**Submission of Environmental Impact Statement for State Significant Development (SSD 7942):
URBNSURF Sydney, Pod B P5 Carpark, Hill Road, Sydney Olympic Park**

ATTACHMENT 2 – Table of Responses to Sydney Olympic Park comments

Figure 3: Saline soils

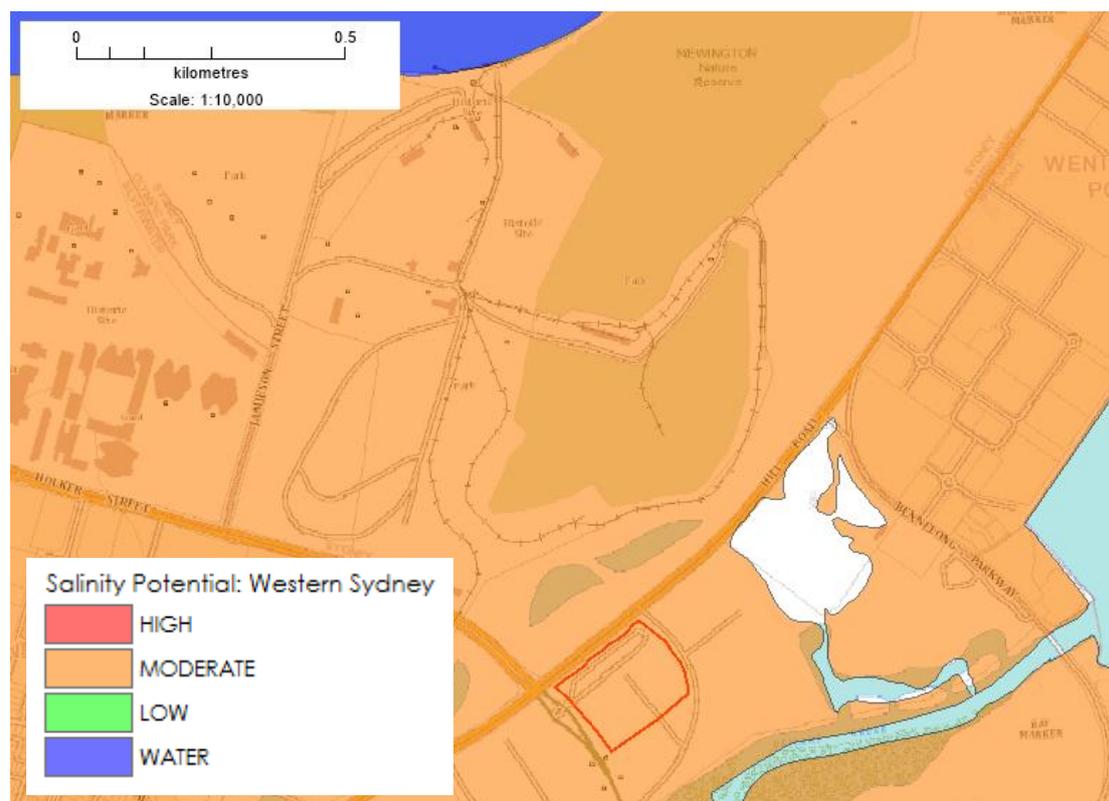
<p>3. Topography and Geology - Reference provided is inadequate and site specific hydro-geological verification and assessment is required with respect to:</p> <ul style="list-style-type: none"> - Saline soils - Acid sulphate soils - Ground water hydrology and hydrodynamics 	<p>The site is built upon 5m to 6m of semi-engineered material and does not intercept the naturally occurring potential acid sulfate or saline soils.</p> <p>Separate geotechnical investigations and field results show a soil pH of 6.0-8.4, suggesting low to no risk of acid sulfate material.</p> <p>Geotechnical investigations undertaken during winter months have also logged the interception of groundwater beneath the surface. Due to the site's topography, groundwater ranges between 4m to 7m below ground level (RL0m to RL2.0m), with a northward hydraulic gradient.</p>	<p>Additional geotechnical and groundwater information has been provided in sections 2.2 and 2.4.1 on the basis of geotechnical investigations.</p> <p>Includes table of geotechnical laboratory testing and figure of groundwater levels.</p>
